8 December 2015

Submission from UNSW Tiggers Parents' Committee to TfNSW re: Modification Report: SSI-6042 MOD 4, Stop changes – High Street, Randwick

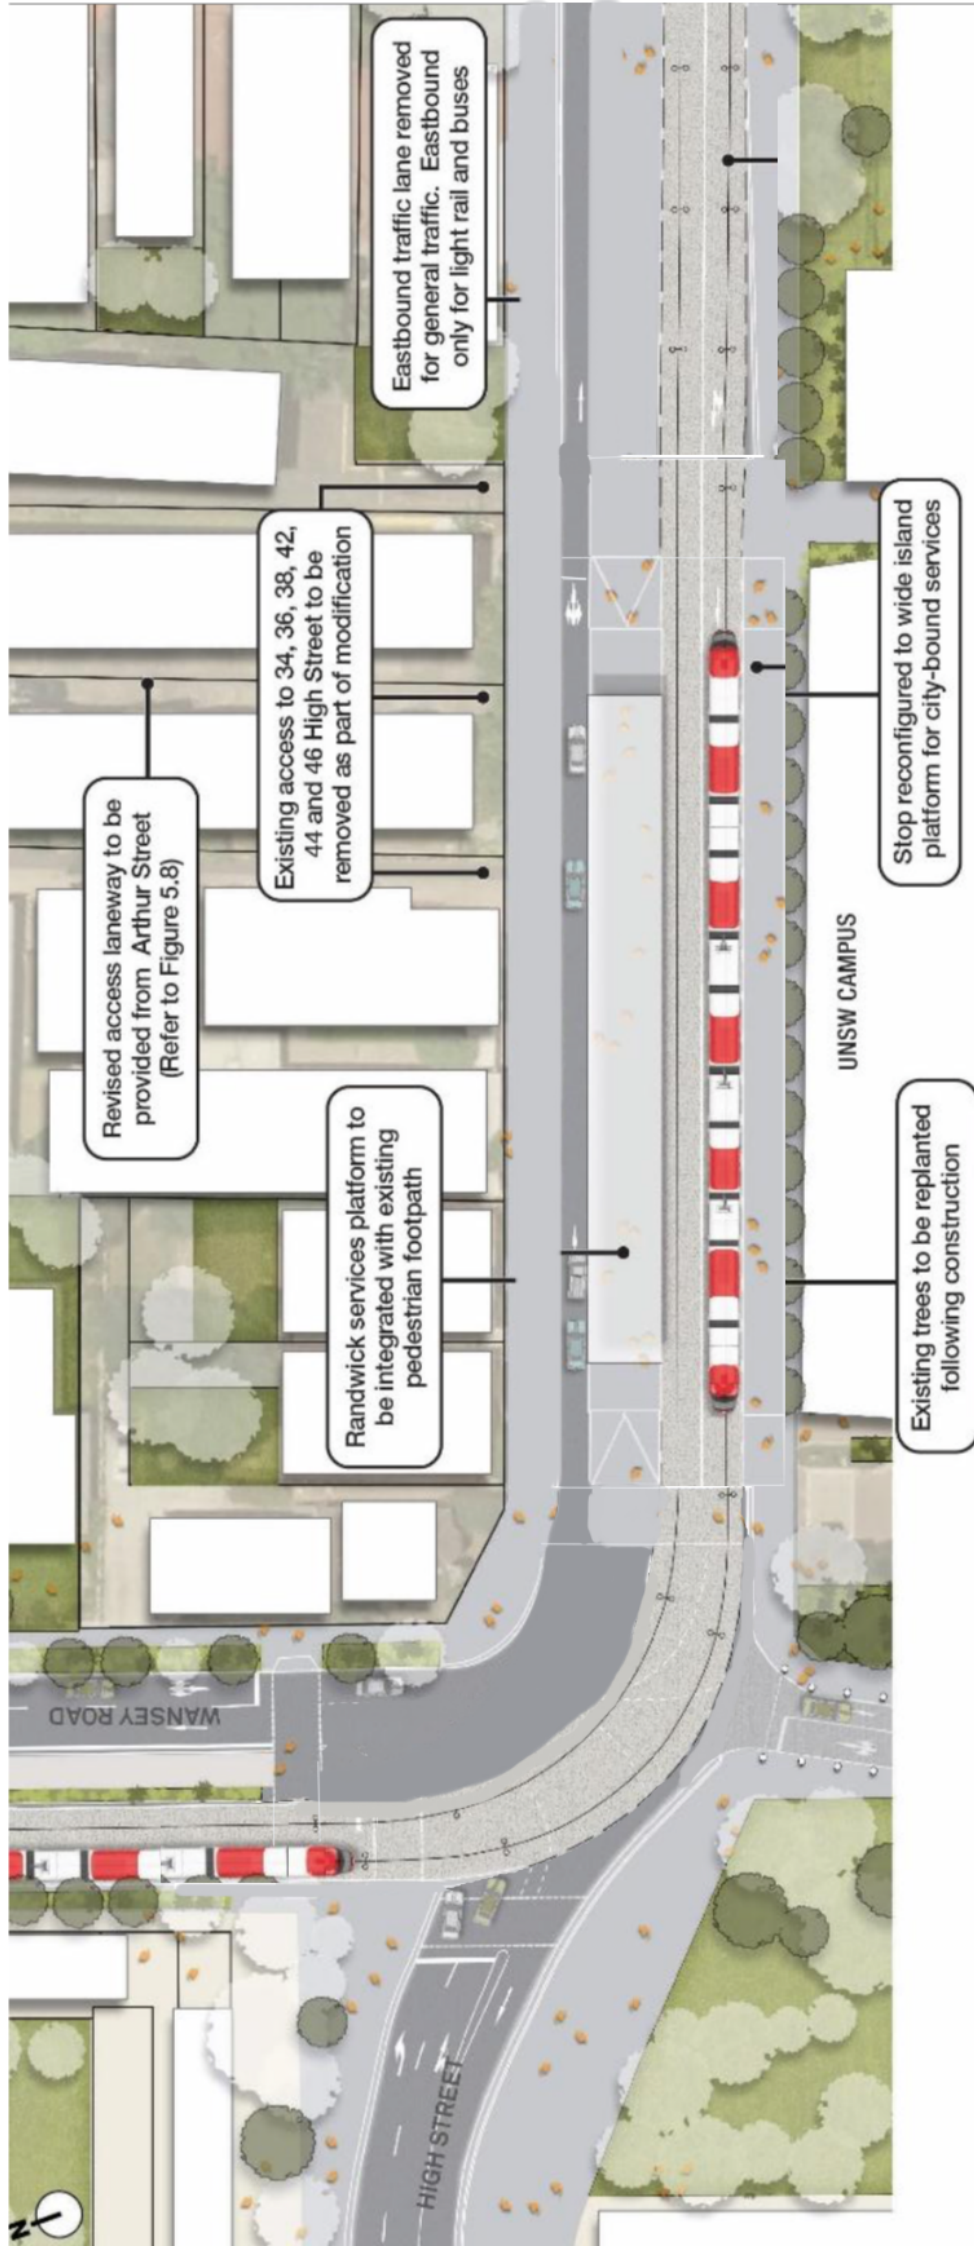
The CSELR proposed access road for residential addresses SP9261 (42 High Street), SP22052 (44 High Street), Lot 2 DP234000 (46 High Street) and Kenvale College Lot 110 DP836801 (36-38 High Street) is through Lot 1 DP330632 (Centre's western section of the Garden) and Lot 1 DP60283 (eastern section of the Garden and Childcare Facility), would divide the Garden reducing the space to approximately one third of its current space.

Attachment 2: Property boundary with constraints

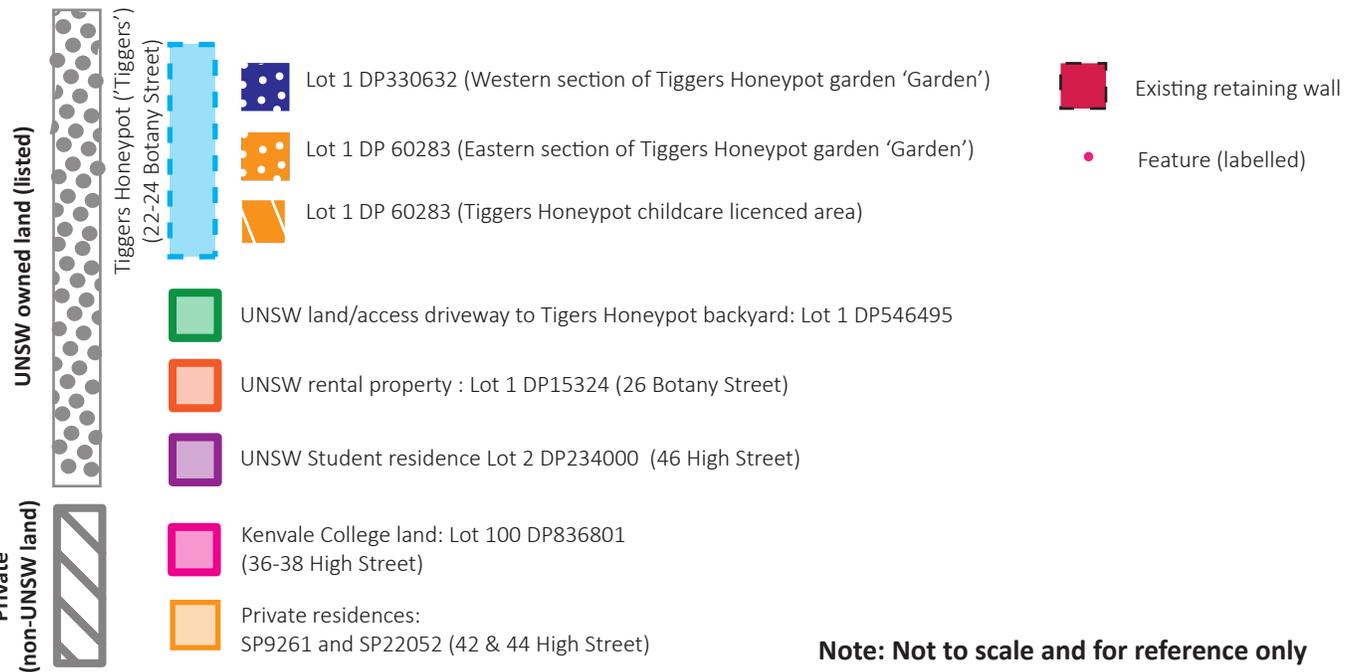
- iv. Level difference between Centre and adjacent properties (Lot 2 DP234000 is 1.6m (approx.) level difference from Lot 1 DP60283 (closest to Centre), and 0.7m (approx.) level difference at the most western connection of SP9261 to Lot 1 DP330632. (See Attachment 2);

- v. Reinforcement or rebuilding of current retaining wall (plus monitoring during and after construction) between the Centre and adjacent properties noting especially impacts on the structure of the Centre's building;

Attachment 3: Alternate Design proposed by Parents' Committee

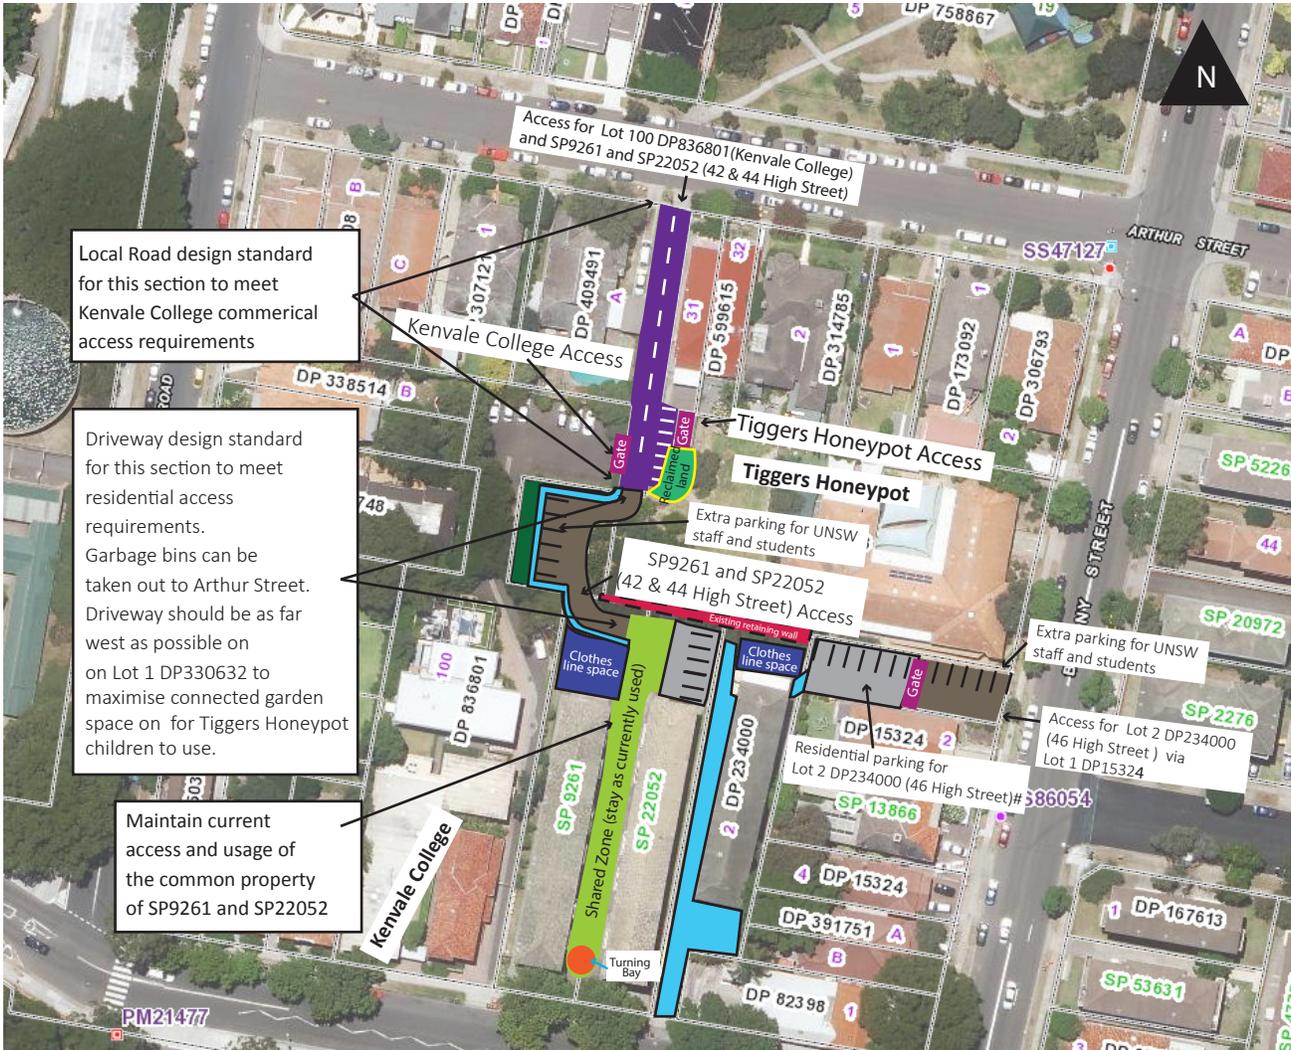
The Parents' Committee have consulted with engineering and planning professionals and experts and have prepared for formal consideration by TfNSW, and UNSW, the attached alternate design that builds on and varies the existing design, overcoming some current issues and minimises adverse impacts to the Centre (Attachment 3). It achieves this principally by avoiding a single access road for all the affected properties and does not divide the garden in two separate areas. This design offers a more practical and commercially sound variation of the current proposed access road with regard to both construction and maintenance.

- A. Residential properties 42-44 High Street (SP9261 and SP22052) and Kenvale College (Lot 110 DP836801, 36-38 High Street) would use the existing UNSW access driveway (Lot 1 DP546495) and any land identified by TfNSW and UNSW to create a suitable road width. This section would meet the standard for the College's commercial requirements.

- B. Kenvale College property connects at junction point of existing UNSW access driveway.
- C. Going south from key feature A. the access road would run the western section of the Centre's Garden (Lot 1 DP330632), with minor use of eastern section of the Garden and Centre (Lot 1 DP60283), to link the residential properties 42-44 High Street to existing UNSW access driveway. This road would be to a driveway standard road. The access point to residential properties 42-44 High Street from the Garden would be at the junction point of the Garden where the smallest level difference is located.

- D. The driveway on the Centre's Garden is pushed as west as possible along the boundary of the Garden to maximise the Garden size.
- E. UNSW property 26 Botany Street (Lot 1 DP15324) is used for the access requirements for UNSW residential apartment 46 High Street (Lot 2 DP234000) and remaining space on the land be used as UNSW parking facility.
